PROJECT NAME: Overlook at Oxbow

PROJECT # 2018-001402

Re: Response to EPC Conditions of Approval for Project #2018-001402; Site Plan EPC SI-2018-00171

SITE PLAN

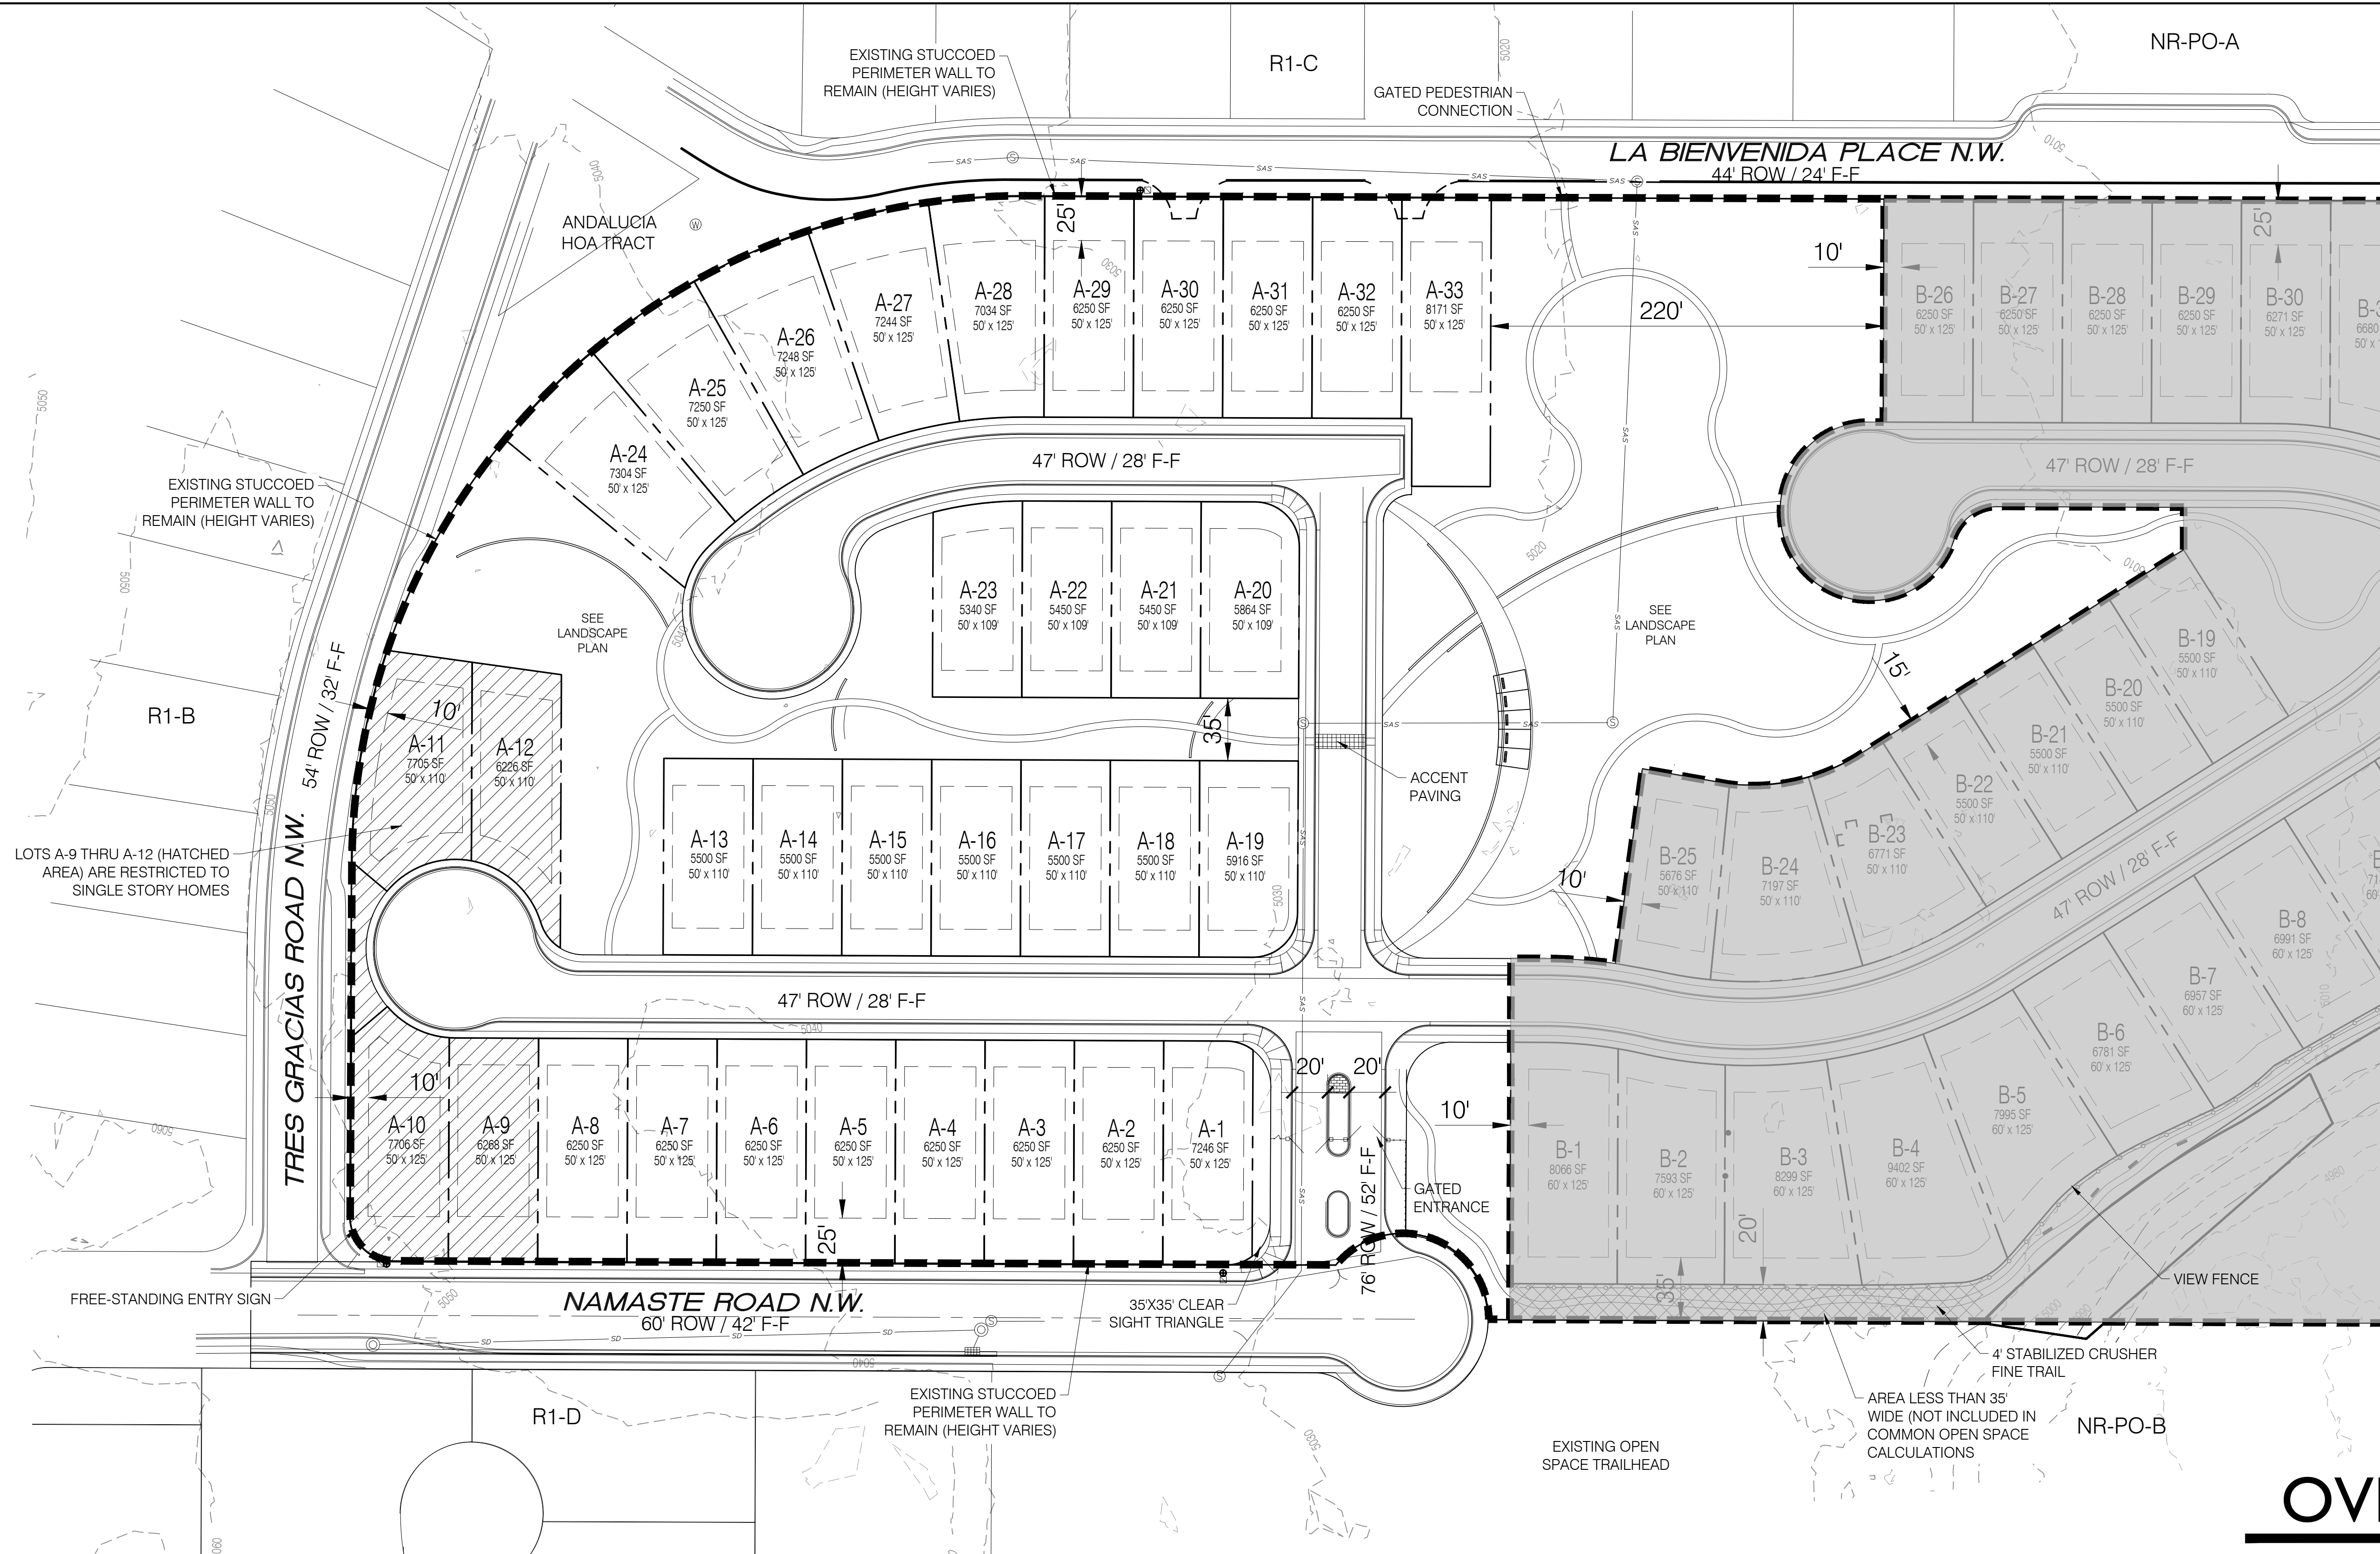
- B. A note shall be added to the Site Plan that states all new buildings and landscapes will comply with IDO Sections 14-16-3-6(D)(6), Colors, in Coors Boulevard VPO-1 and 14-16-5-2(H), Major Public Open Space Edges.

- iv. The following comments need to be addressed prior to DRB:
Show the clear sight triangle and add the following note to the plan:
"Landscaping and signage will not interfere with clear sight requirements. Therefore, signs, walls, trees, and shrubbery between 3 and 8 feet tall (as measured from the gutter pan) will not be acceptable in the clear sight triangle.

Applicant Response: This note has been added to Sheet 1.

Applicant Response: *The clear sight triangle and note have been added to both the Site and Landscape Plans.*

SITE PLAN - CLUSTER A

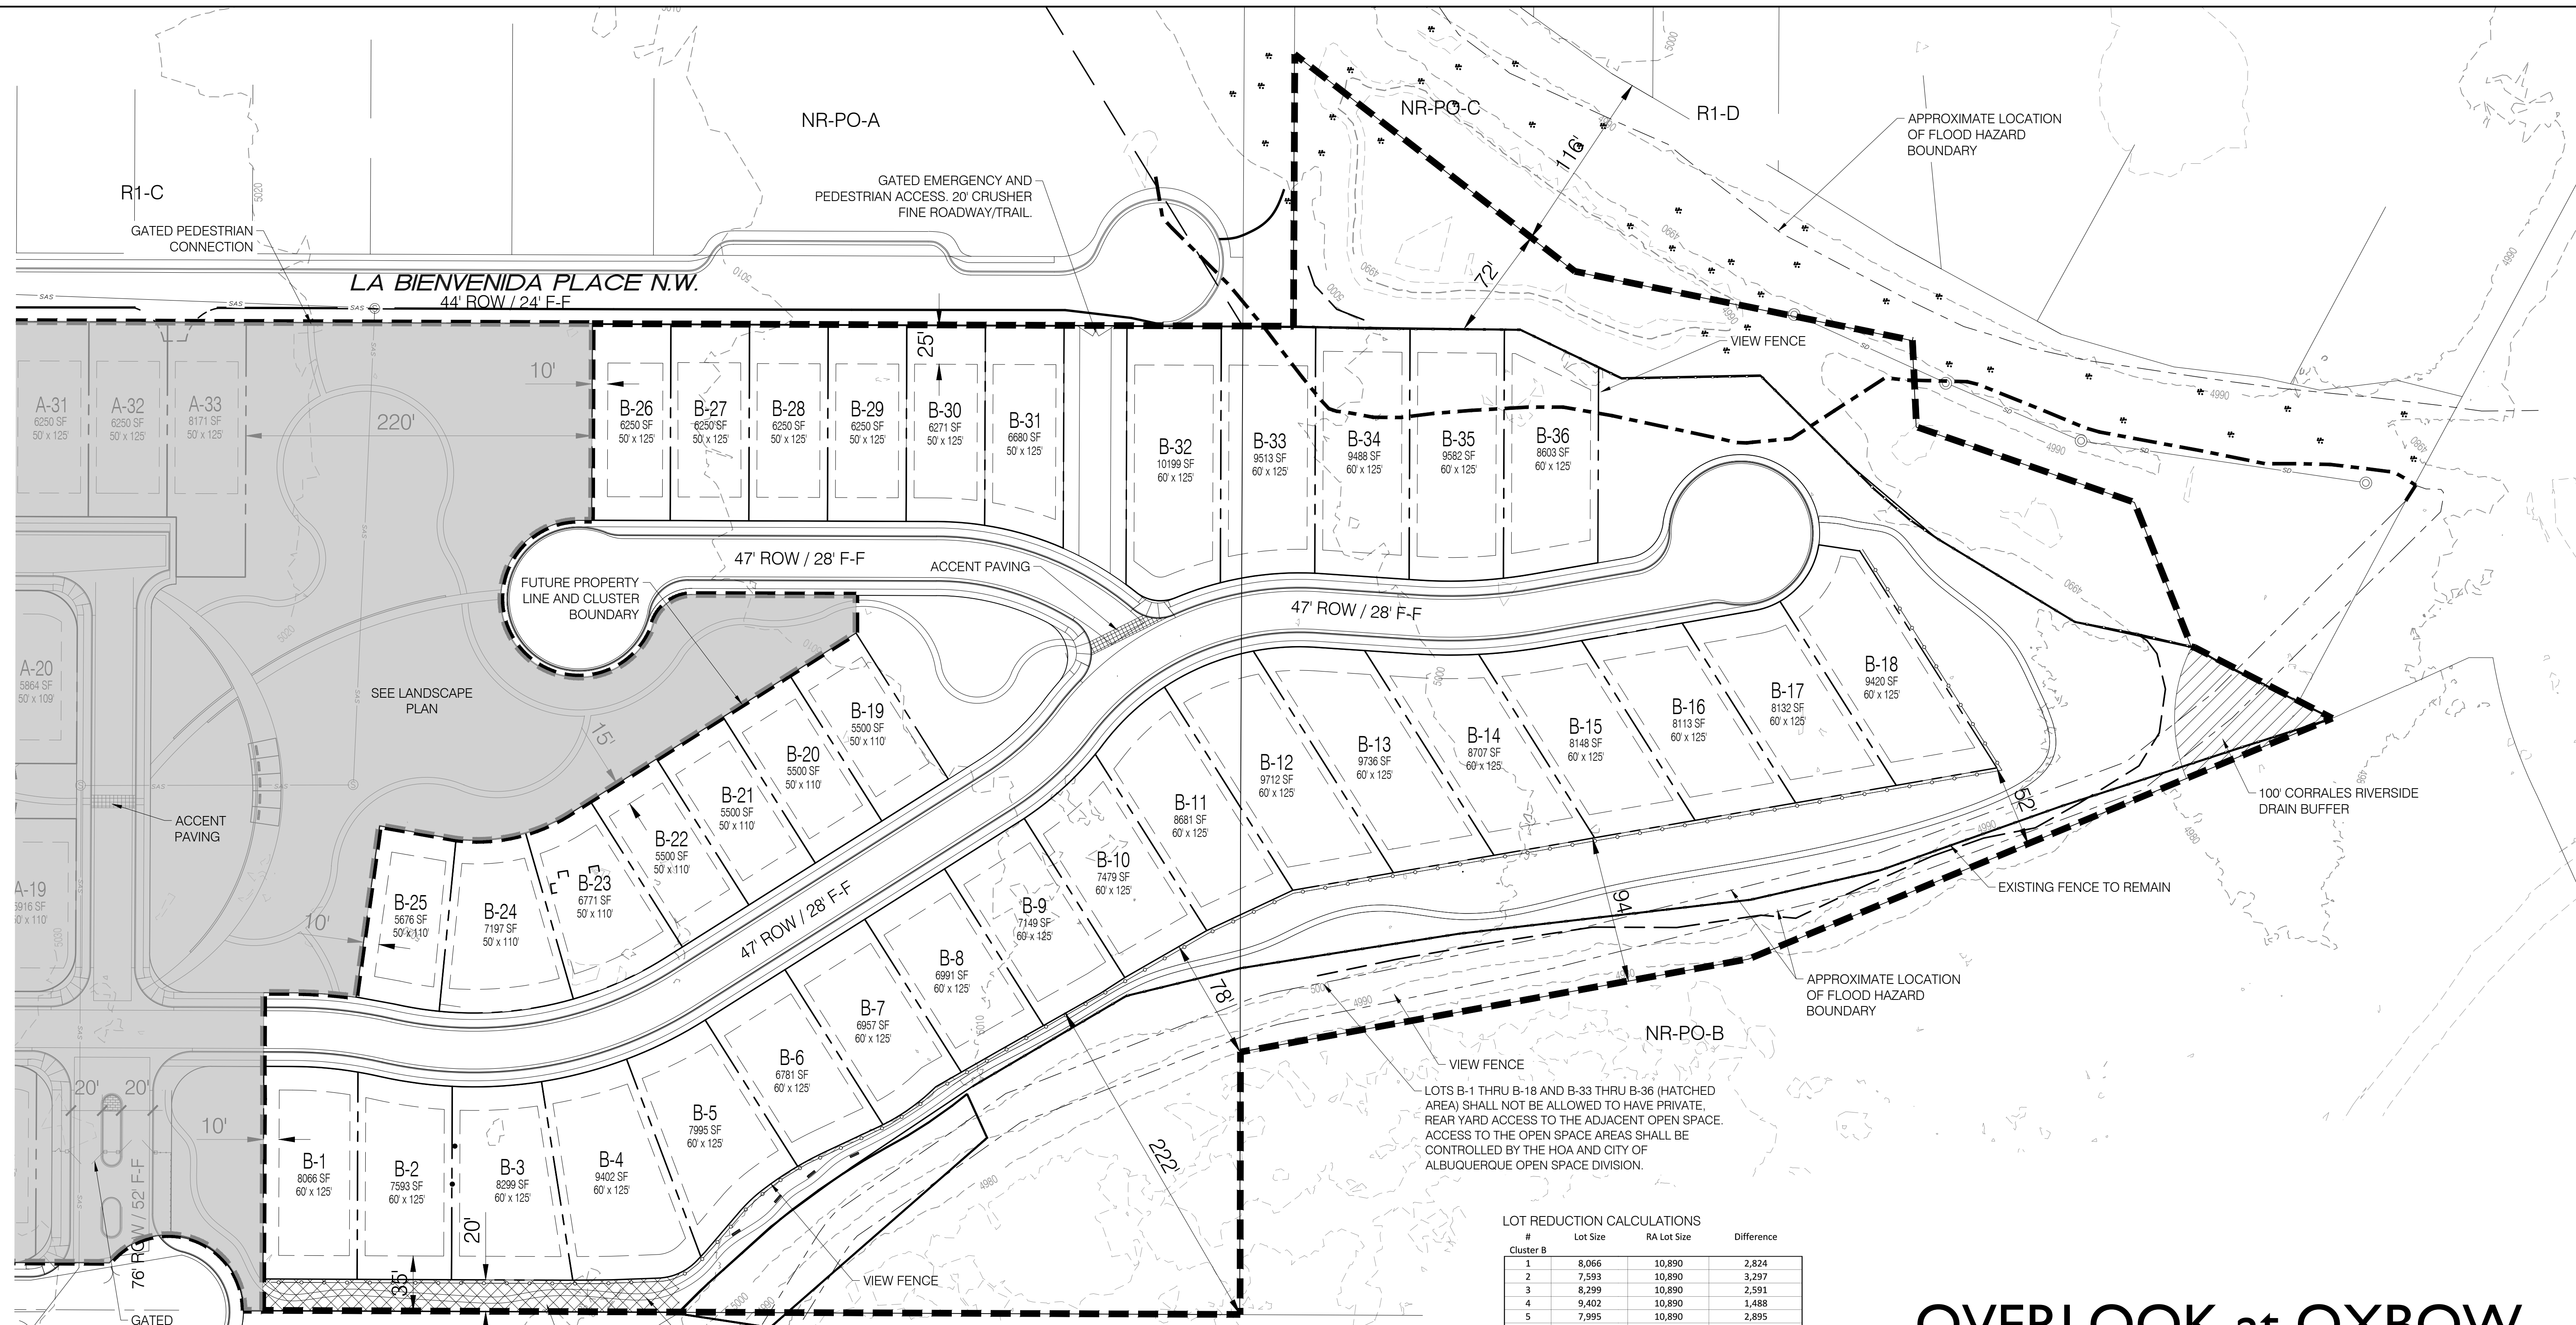
- A. Setbacks at the perimeter of each cluster are required to be pursuant to the underlying R-A Zone District: Front- minimum 20 feet; Side- minimum 10 feet; Rear, minimum 25 feet. All lots shall meet the required setbacks, and the following lots shall be revised so that they comply:
 - Cluster A: Lots A-11 and A-24 through A-33
 - Cluster B: Lots B-1, B-25, B-19 through B-25, and B-26

- A. The calculations that produced the open space figures shall be shown, step by step, in order to determine compliance and shall be adjusted as needed to meet applicable requirements.

- C. A comparison of the minimum required lot size in the R-A zone (10,890 sf) and each proposed lot size is needed to figure out the "100% of the area gained through lot reductions". A table showing the size differential for each lot, and a summary total, shall be provided and clearly show if the figure for "30% of gross project site" or the figure for the area gained through lot reductions is the larger.

Applicant Response: The drawings were modified prior to the EPC hearing. In addition, there are two new sheets added to the set that provide each individual

cluster at a scale of 1" = 50' with the setbacks dimensioned. The exhibit is also included on the new detail sheet.

Applicant Response: The calculations have been added to the larger scale drawings for each cluster.

Applicant Response: The information regarding the required open space for each cluster has been updated on the Site Plan and the table with the calculations has been added to the larger scale drawings for each cluster.

OVERLOOK at OXBOW
SITE PLAN - DETAILS

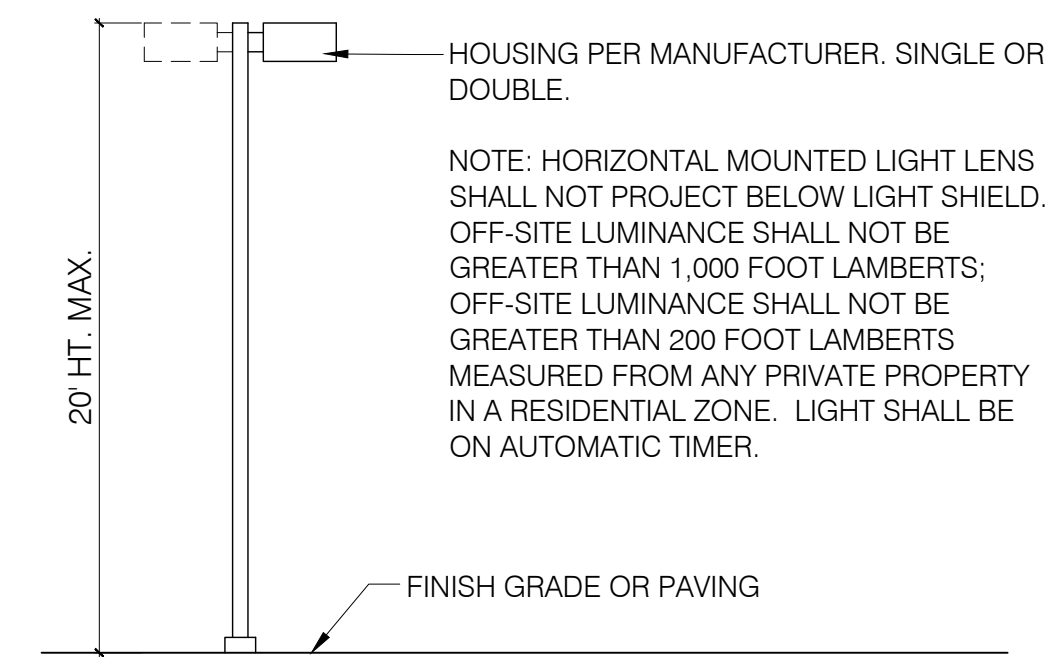
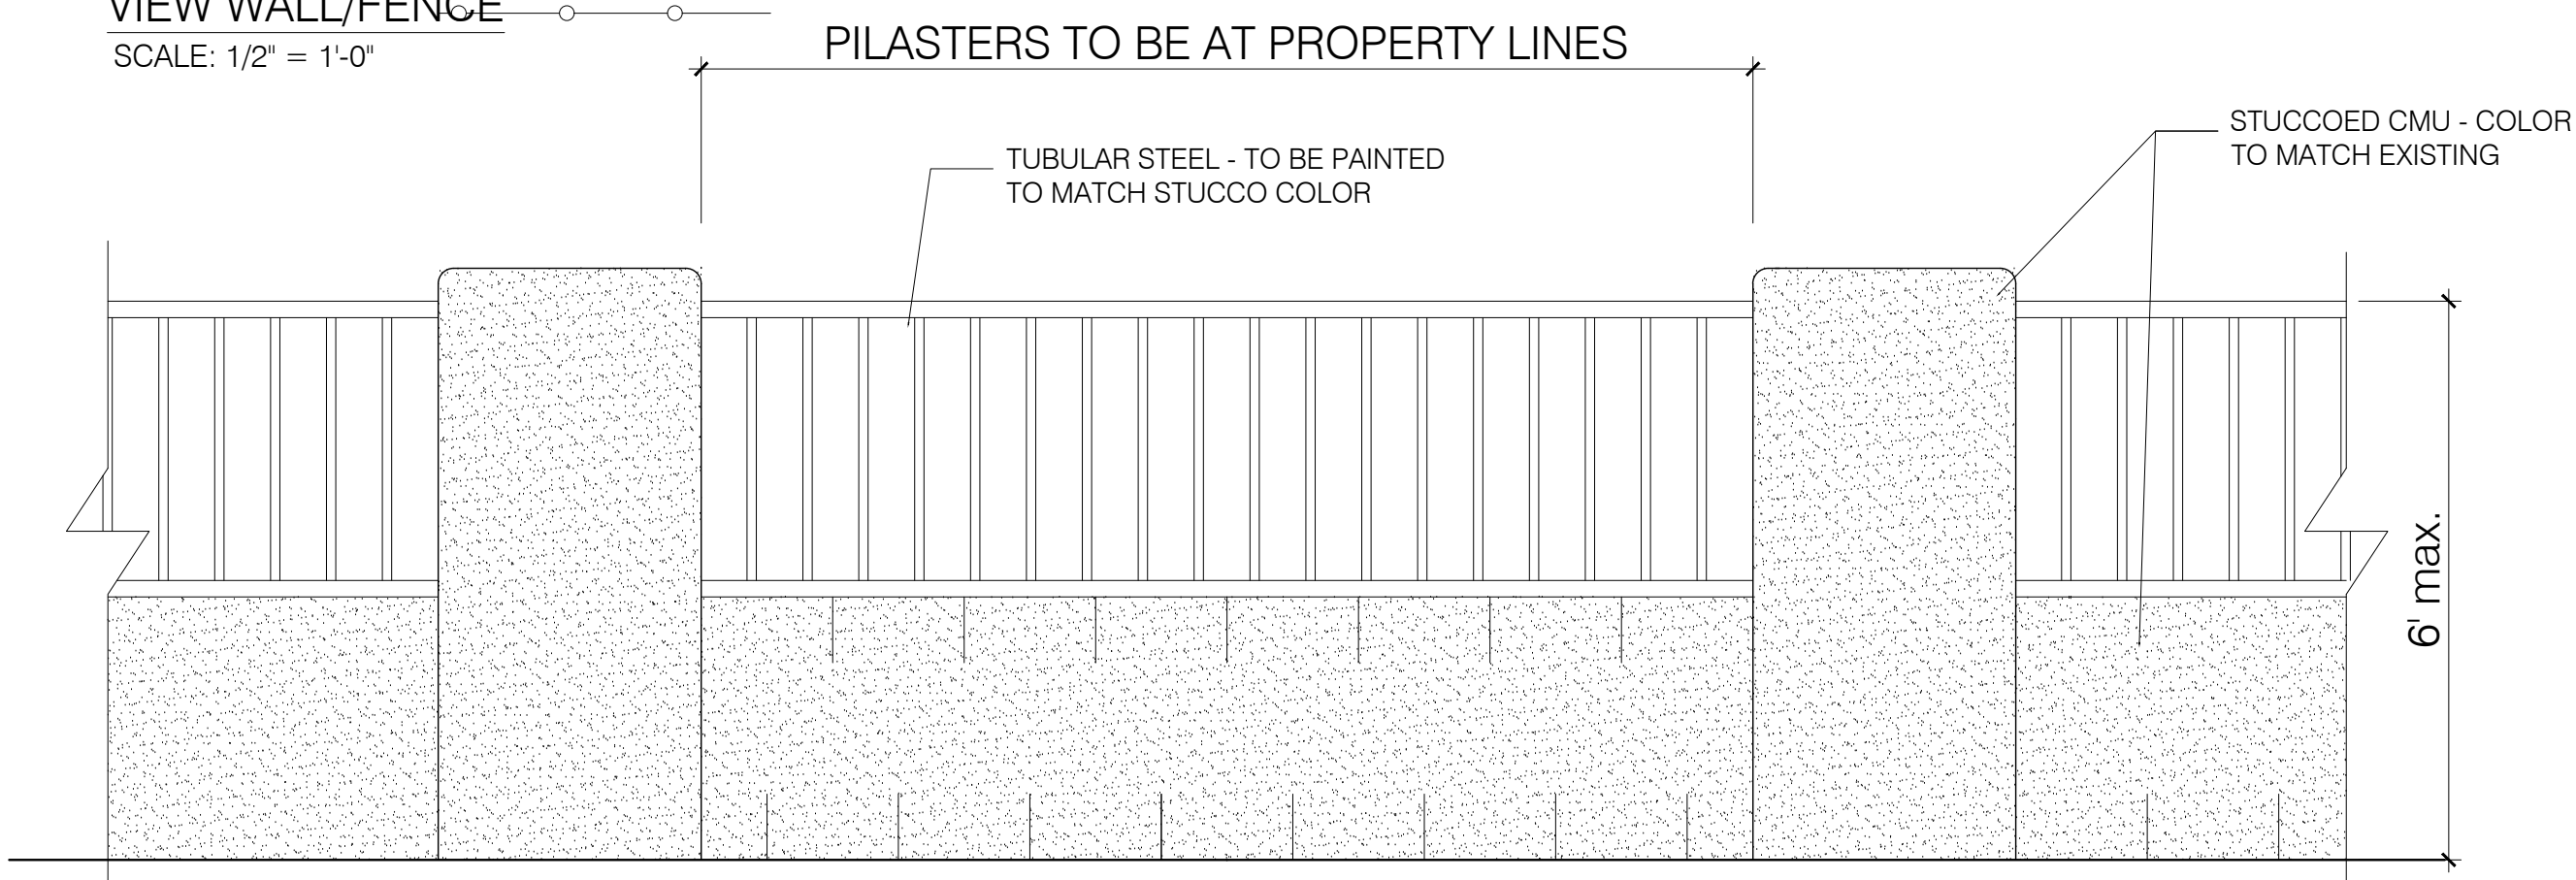
- C. The details for street section, free-standing entry sign, and view fence shall be moved to a separate detail sheet.

- D. A light pole detail and a wall detail shall be added to the detail sheet so that compliance with IDO Sections 3-4(C)(5)(d) and 5-7(D)(I) can be evaluated.

Applicant Response: The detail sheet has been added to the site plan drawings.

Applicant Response: The light pole and wall detail have been added to the detail sheet.
